**CITY OF ALBUQUERQUE  
PLANNING DEPARTMENT**

**June 17, 2015  
DRB Comments**

**PROJECT # 1005455**

**RE: Lot B, El Jaral**

LOTS I THRU II  
 FINA SUBDIVISION  
 BEING A REPLAT OF LOT B OF  
 EL JARAL SUBDIVISION  
 AND  
 TRACT 303A  
 M.R.G.C.D. MAP NO. 35  
 PROJECTED SECTION 12, T 10 N, R 2 E, NMPM,  
 CITY OF ALBUQUERQUE, BERNALILLO COUNTY, NEW MEXICO  
 JUNE, 2015

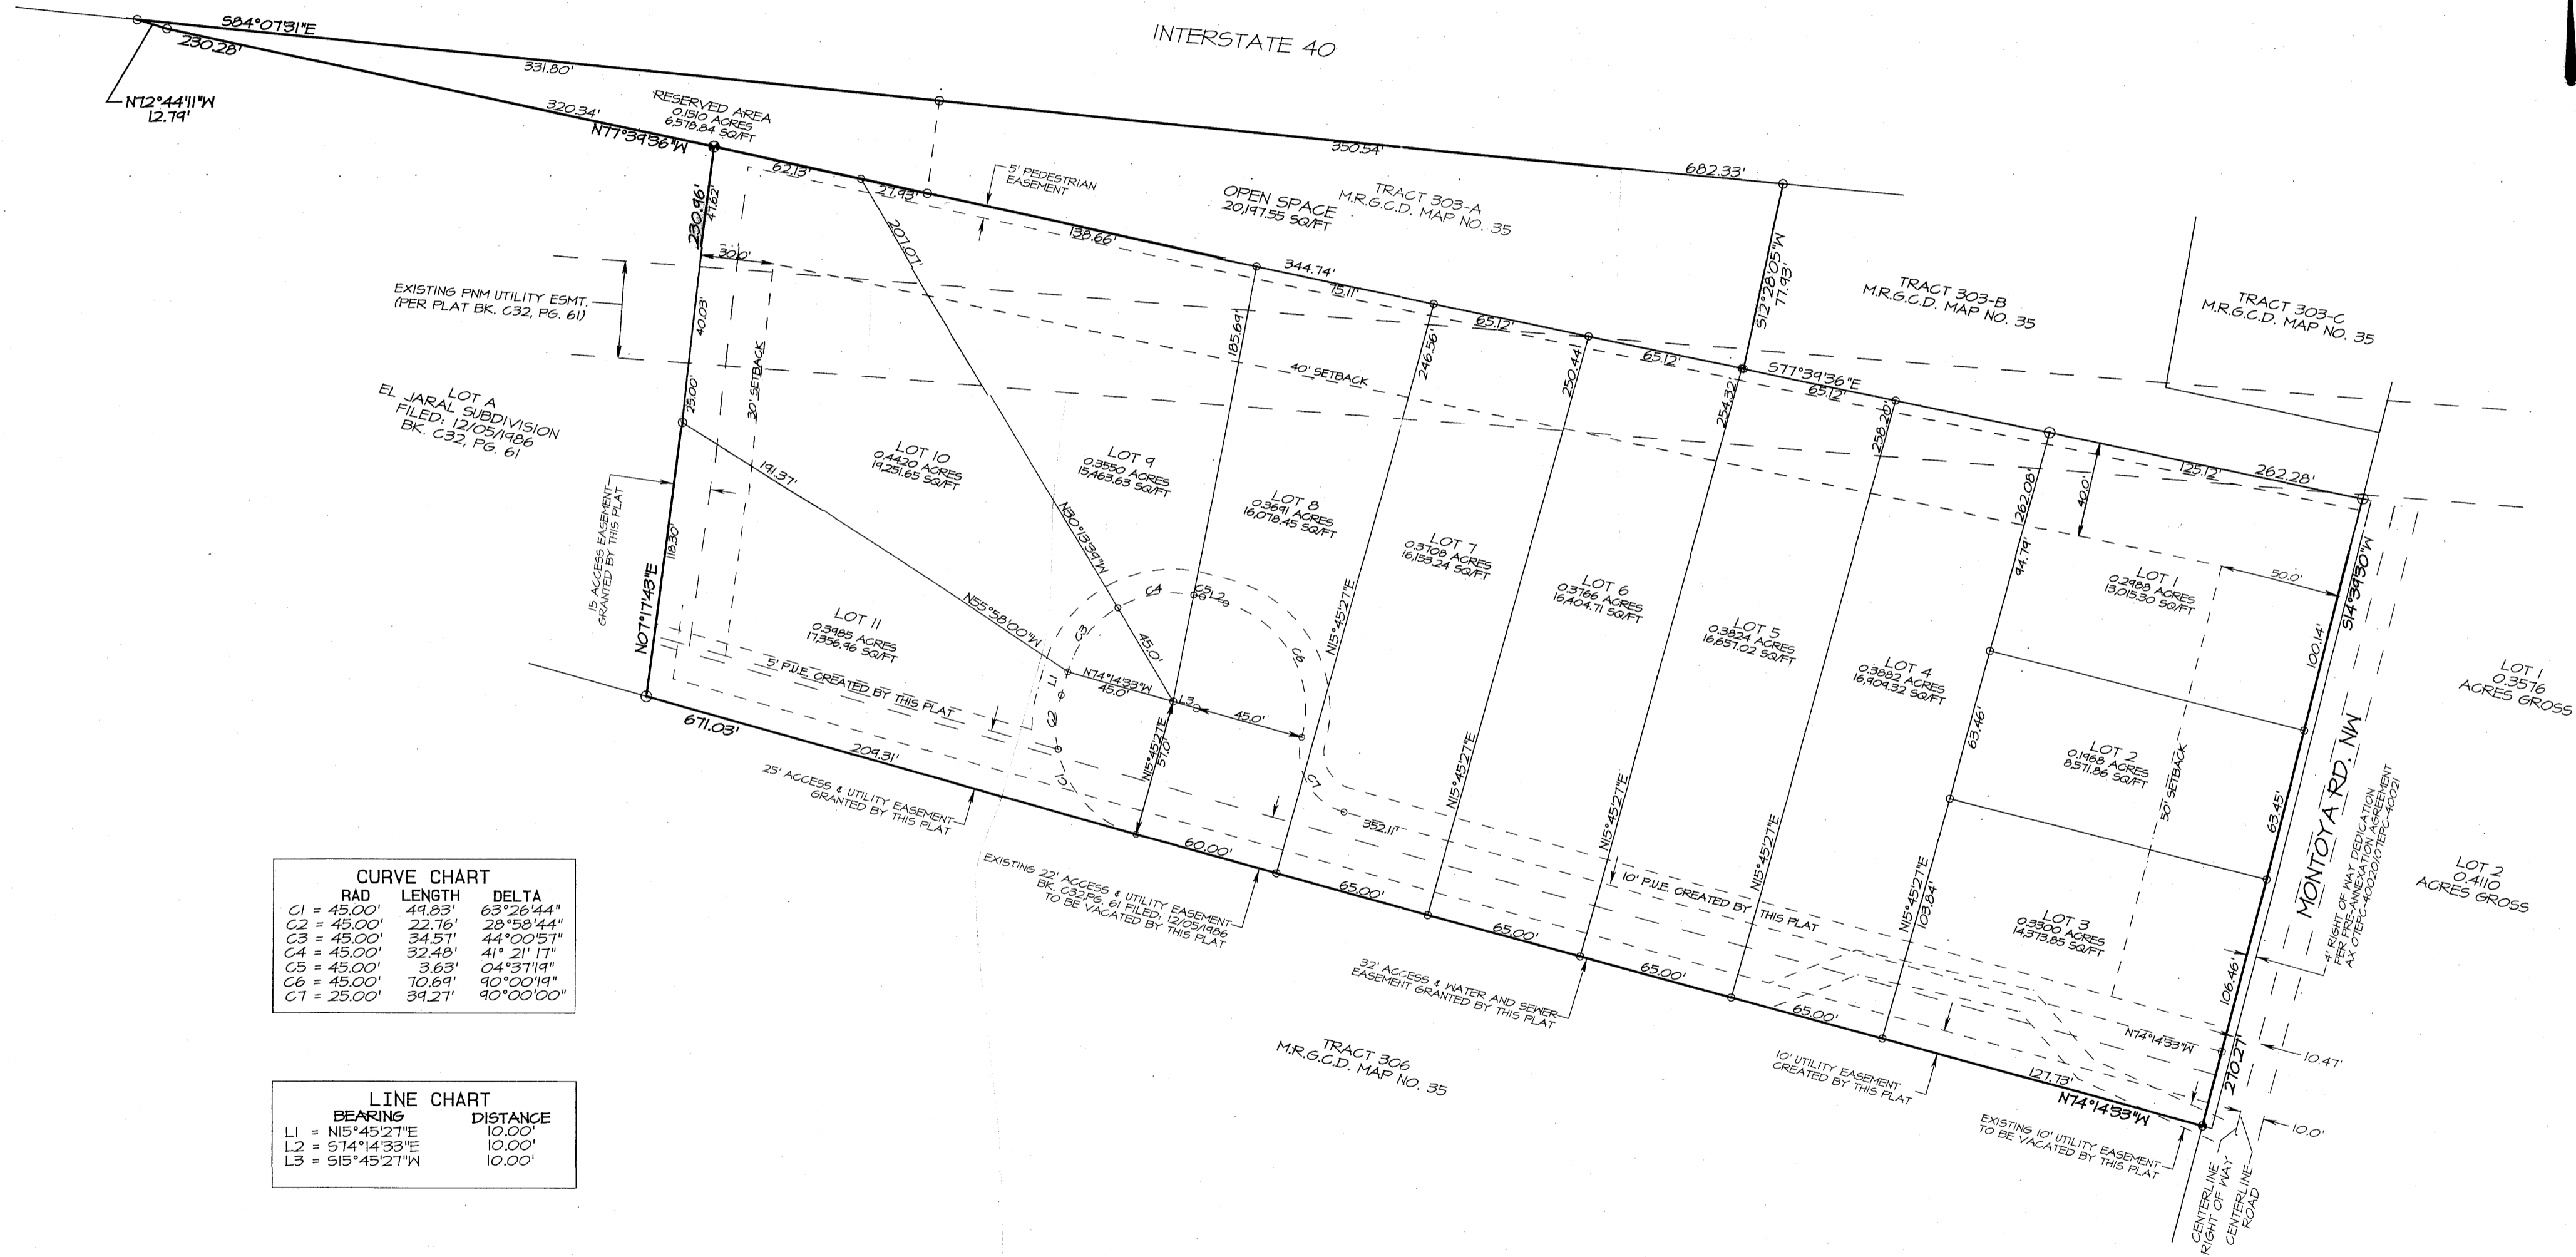
Based on the pre-annexation agreement, Tract 303A should not be included in EPC application or incorporated into the site plan (limited to 10 homes).

Several Subdivision Design Variances will be required for Montoya Street right of way, pavement width, and waiver of sidewalk curb & gutter, as well as for the interior road (even with a reduction to 10 lots with 3 accessing Montoya, the easement will be providing access for 9 lots counting the parcel to the north and one to the west).

There are significant trees on-site that could be preserved with a more creative access, e.g. two 18 ft aisles with trees in 'median' where appropriate for tree preservation. A double loaded access, centrally located, may be more efficient – see examples on page 2 of Exhibit A/ Design Regulations.

LOTS 1 THRU 10  
 FINA SUBDIVISION  
 BEING A REPLAT OF LOT B OF  
 EL JARAL SUBDIVISION  
 PROJECTED SECTION 12, T 10 N, R 2 E, NMPM,  
 CITY OF ALBUQUERQUE, BERNALILLO COUNTY, NEW MEXICO  
 OCTOBER 2014

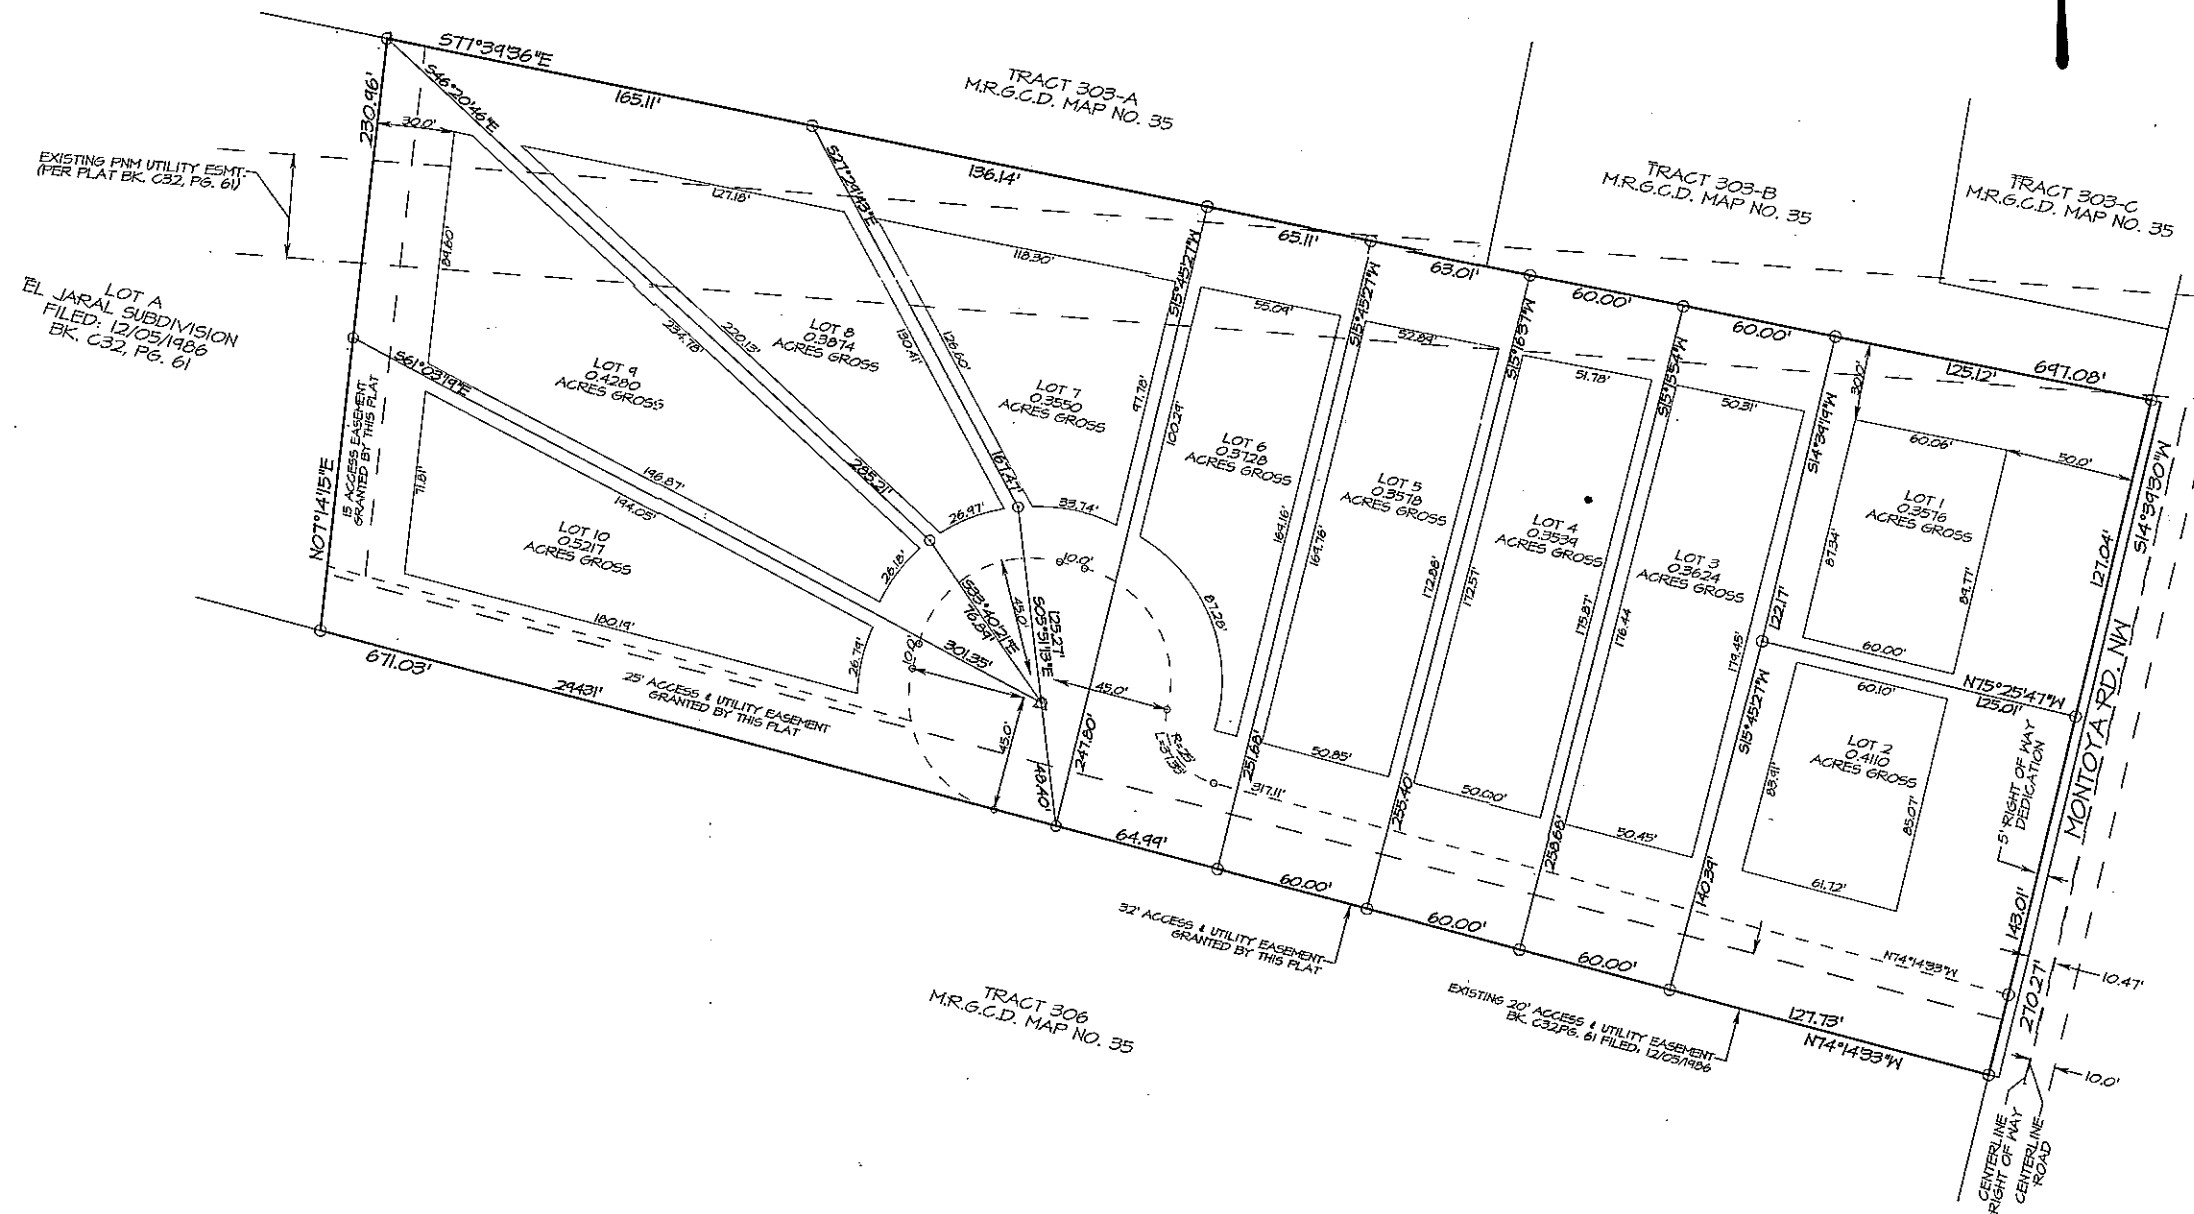
Refer to attached site plan checklist; regarding the checklist note for delegation of future EPC approval, minimum standards from the annexation are NOT optional. Of particular concern is how open space and setback standards are to be met as these are not clear or shown on submitted sketch.

The sliver parcel Tract 303A should be included in EPC application, for a zone change to be zoned same as Lot B and to be incorporated into the site plan.

A Subdivision Design Variance would be required for 9 lots on a 32 foot easement. Given existing trees along the south boundary, additional easement width will be needed to allow meandering vehicular and separated pedestrian access. If a single loaded street is pursued along south boundary it needs to be extended 60' – 100' to the west to minimize exaggerated 'pie-shaped' lots; a double loaded access, centrally located, may be more efficient.
